Morgan and Morecambe Offshore Wind Farm: Transmission Assets

**Appendix H5 to Natural England's Deadline 5 Submission
Natural England's comments on Onshore and Intertidal Ornithology**

Planning Inspectorate Reference EN020028

22 September 2025

Figure 4: Indicative Beach Working Areas for Cable Installation Works

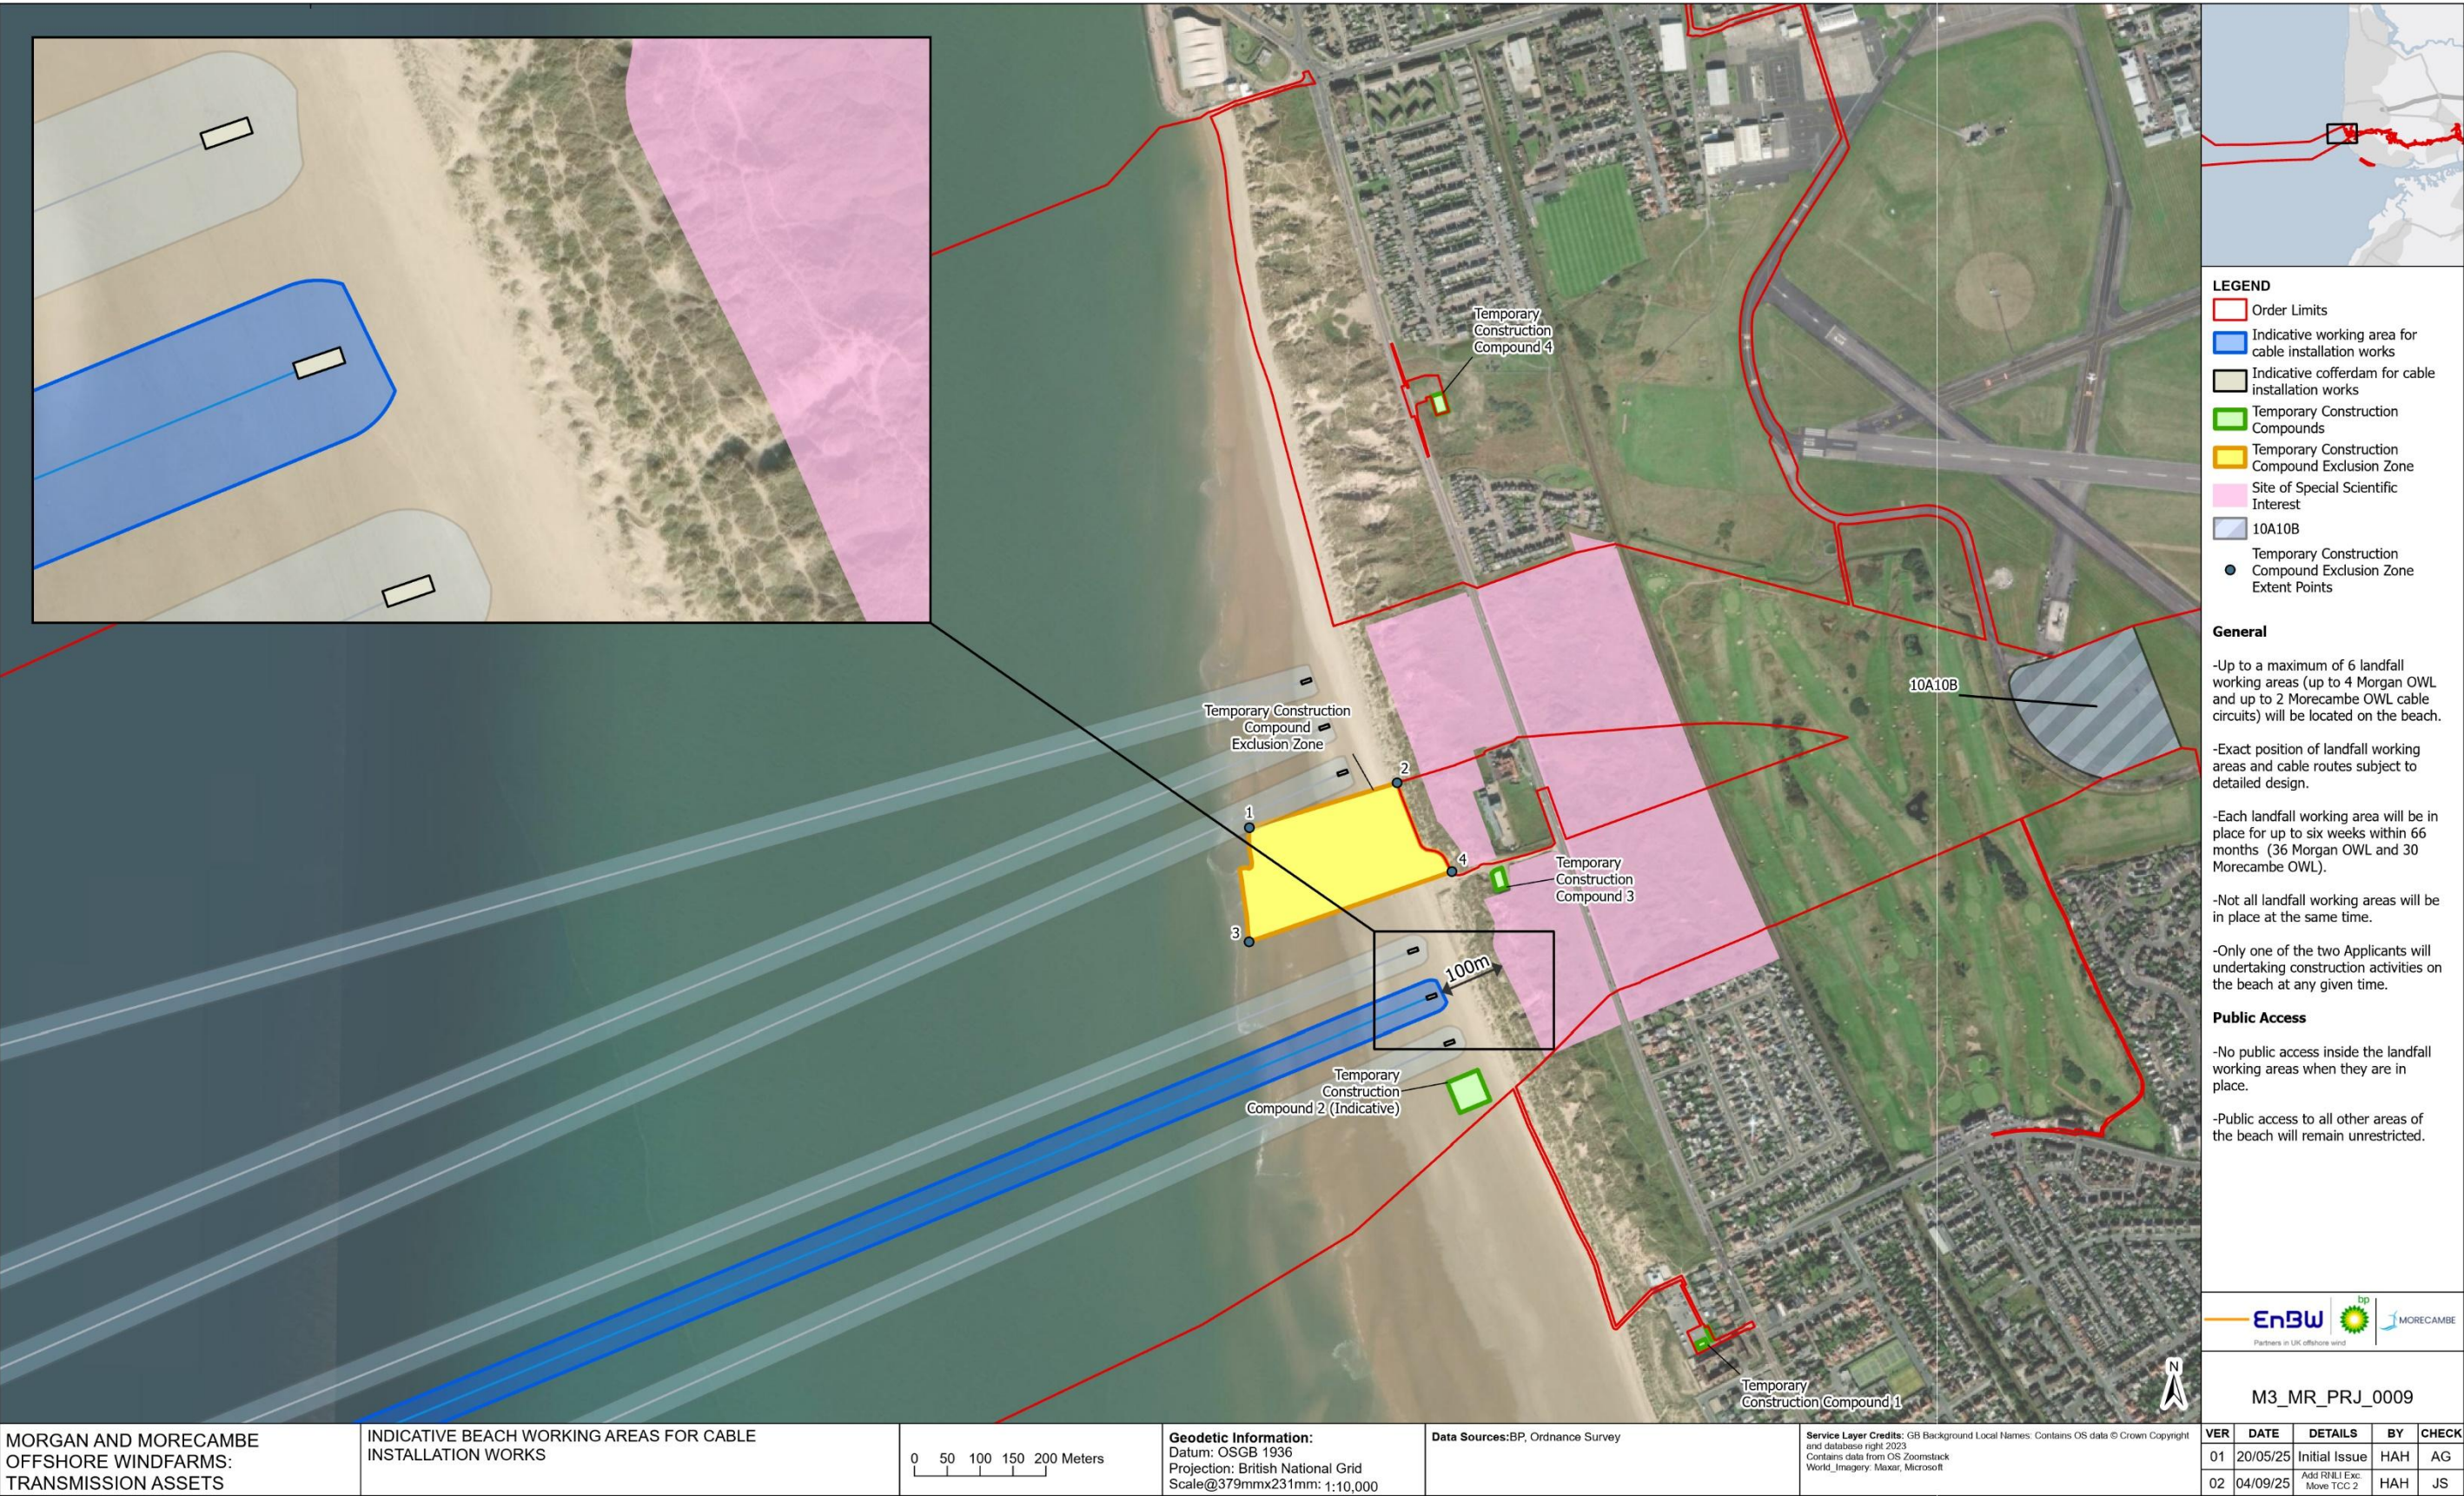
- The OEMP [REP4-059] section 1.6.3.15 includes details on 25m exclusion zones either side of the cable pull in. [AS-081] section 1.13.4.1 states a defined working area extending 25m either side for cable preparation and installation activities. We advise it should be clarified whether this refers to the same 25m exclusion zone or not;
- Clarification that only one cable pull in will be undertaken at any one time. The document includes detail on only one project undertaking work at any one time (section 1.11, 1.13.2, 1.13.3) but that is not quite the same as one cable pull in; and
- We advise that CoT129 (Table 1) should include reference to ‘foraging and roosting’ birds.
